**Permit Number: BCOM2603-0008**

**Description: Auto Retail Shop & Unpermitted 12x16 Prefab Storage Building**

SENT DATE	RETURNED DATE	DUE DATE	TYPE	CONTACT	STATUS	REMARKS
Review Group: 1ST PLAN REVIEW						
3/27/2026	4/10/2026	4/13/2026	FIRE MARSHAL	MATTHEW STARLING	DISAPPROVED	See Comments
Notes:

BLDG KEY PLAN
1:50

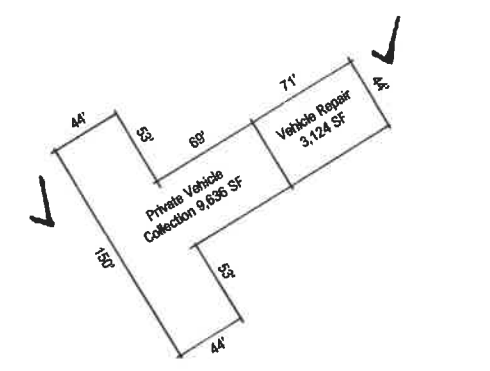
1. Provide interior layout of the building. 2. No fire extinguishers marked on plans. 3. Garage doors cannot be used as an exit.						
Please make corrections to the plans and resubmit. MJS						
Review Group: 2ND PLAN REVIEW						
4/14/2026		4/28/2026	FIRE MARSHAL	Fire Bucket		
Notes:						
Review Group: AUTO						
3/27/2026	3/27/2026		COMMERCIAL INTAKE	CP Bucket	APPROVED	SITE2208-0002
Notes:						
3/27/2026	4/1/2026	4/13/2026	COMMERCIAL BUILDING REVIEW	Brad Sutton	DISAPPROVED	
Notes:						
Need a plan drawn to scale. Cannot count garage doors as exits. Plan must have all rooms in the building shown						
4/14/2026	4/16/2026	4/28/2026	COMMERCIAL BUILDING REVIEW	Brad Sutton	DISAPPROVED	
Notes:						
Plan is not drawn to scale. Cannot calculate occupant load or diagonal. Second exit will be needed due to travel distance. Second exit must be 1/2 the total diagonal distance of the building from the front doors, and located between the wall separating the garage from the business occupancy. Cannot egress through garage.
